Our Ref: NW/ARU/16/17E

Date 14th October 2019

RE:- Merry Engand Nursery, Dappers Lane, Angmering. BN16 4EN

Neville Wren
Designing Out Crime Officer
Sussex Police Headquarters

TITLE:
TYPE 2 - ROOF PLAN

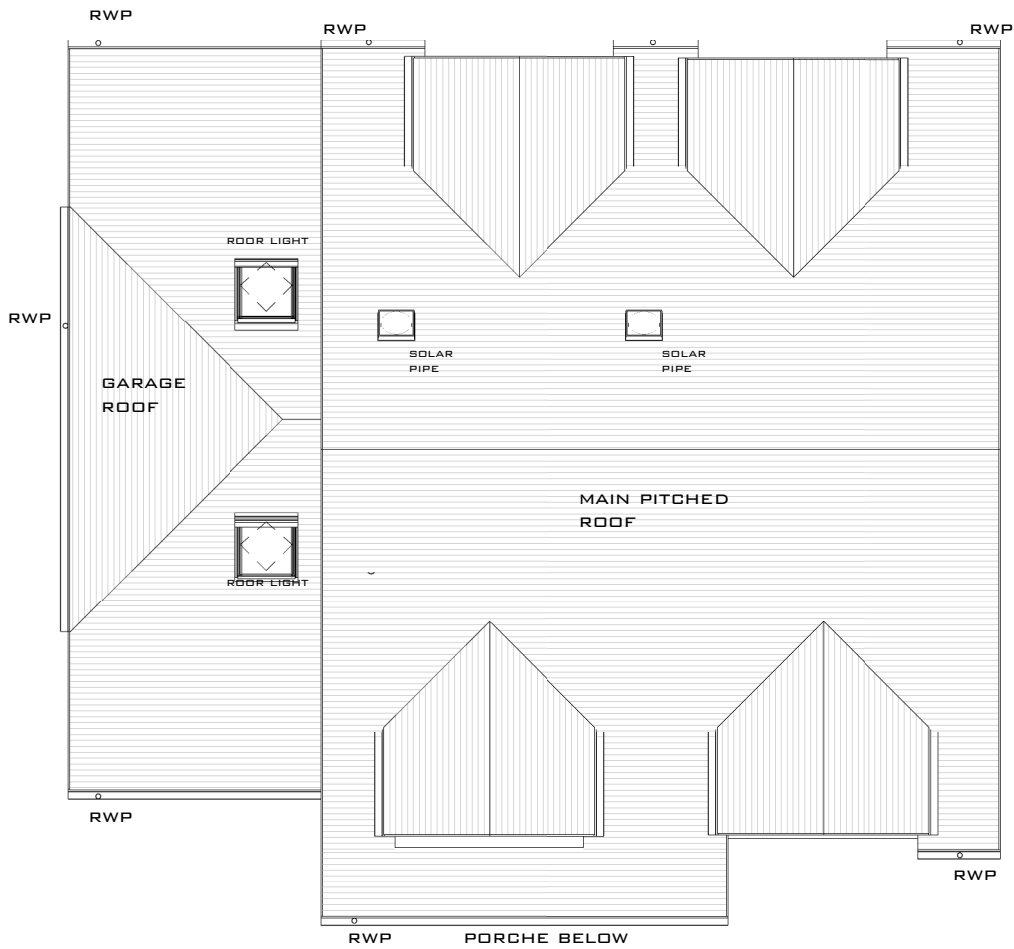
I have no concerns regarding the appearance of the dwelling houses, but draw the applicant's attention to Chapter 22 of Secured by Design Homes 2016 in respect of security specifications for easily accessible windows, roof windows and glazed roof lights within the new house types and the roof lantern in the farmhouse flat roof.
